RE: Intake Screening- 2204-043

Project: 6427 E. Mercer Way new SFR.

Please find our responses to your intake comments:

LOT SLOPE CALCULATIONS

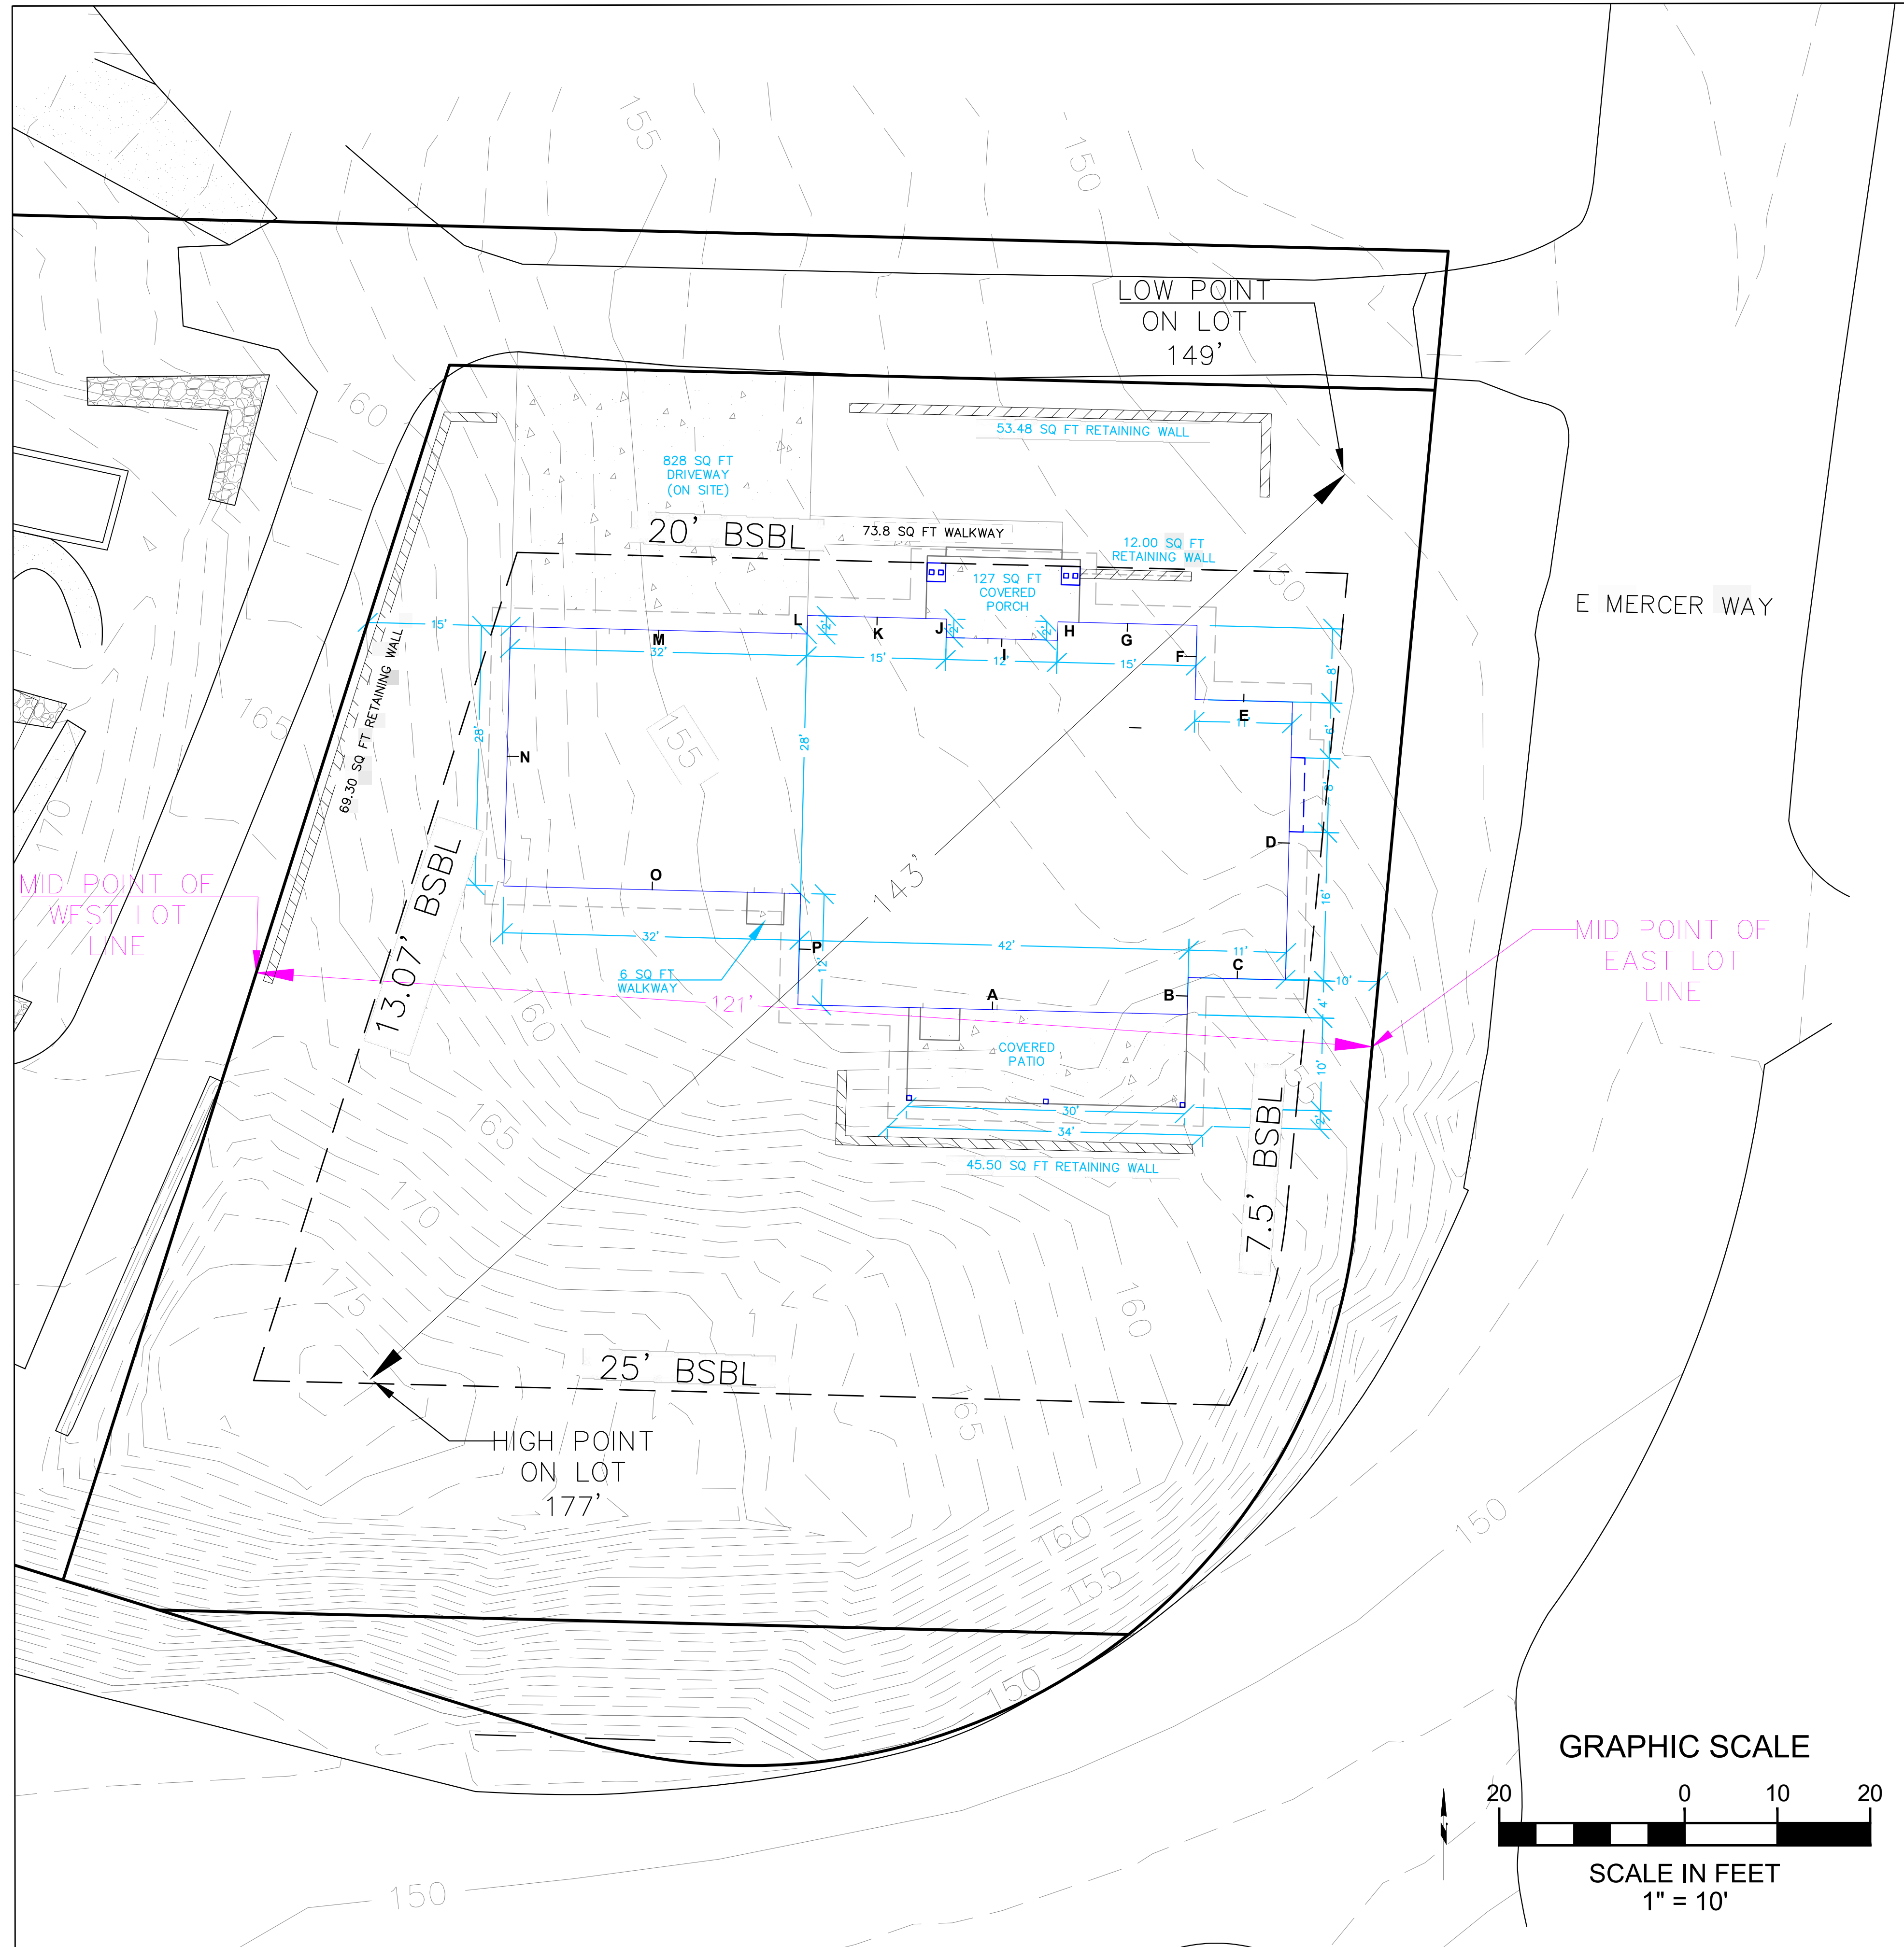
2. Tim McHarg- Lot coverage and GFA exclusion calculations are shown on Sheet SP-1. However, GFA calculation and hardscape coverage calculations are not included in the plan set. Please provide these calculations on a plan sheet.  
*Calcs added to the plan set.*
